BLACKTOWN
INTERNATIONAL
SPORTSPARK

SIGNPOSTING

Stage 3 - Road safety audit

For:
BLACKTOWN CITY COUNCIL

Figure 4: Site 1 Signage Elevation – Westlink M7

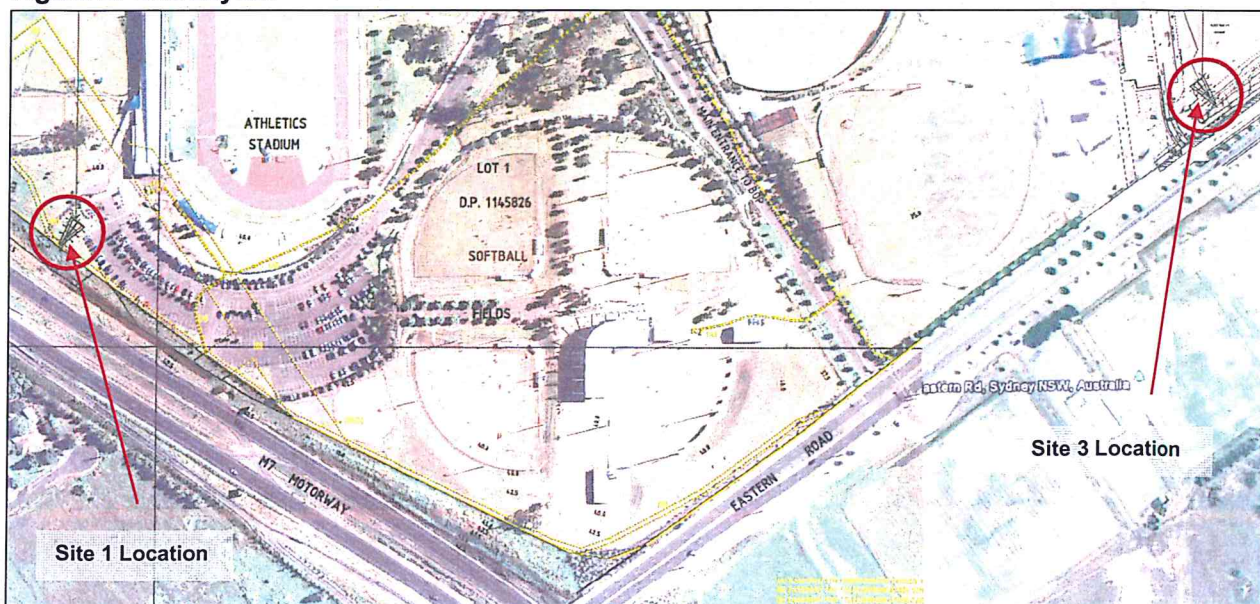
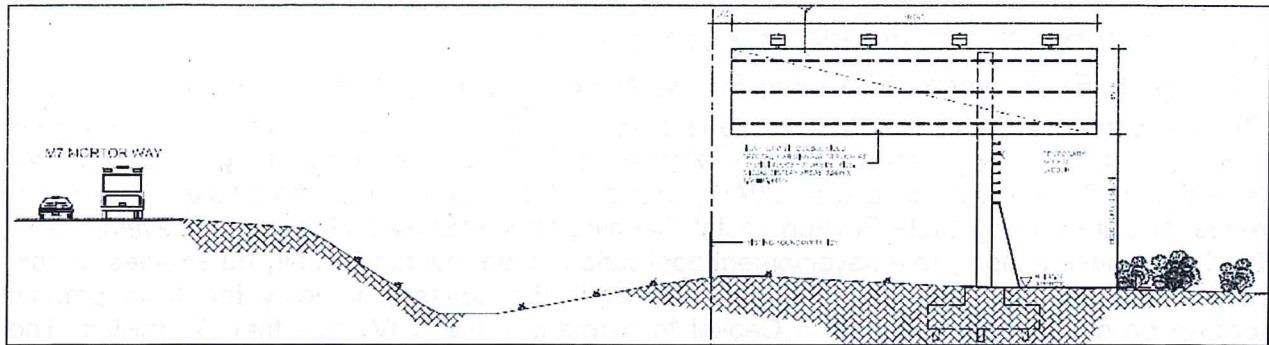
3. The location of sign 1 is 150m east of Eastern Road, behind an advanced direction sign for access to the M4. This sign does not obstruct the view of any road hazard, intersection, traffic control or emergency access point. However, sign 1 may distract a driver of this advanced direction sign particularly during the night.

5. Glare from sign 1 glare could extend onto Eastern Road.
6. Details of the luminance have not been provided. However, the level of reflectance is not to exceed the minimum coefficients of luminous intensity per unit area for Class 2 A Material as set out in Australian Standard AS/NZS 1906.1:2007.

Grounds for rejection			
Assessment Date	28.10.11			
Auditor	Brett Morrison			
	Diane Morrison			
Summary	Sign requires more than glances appreciation
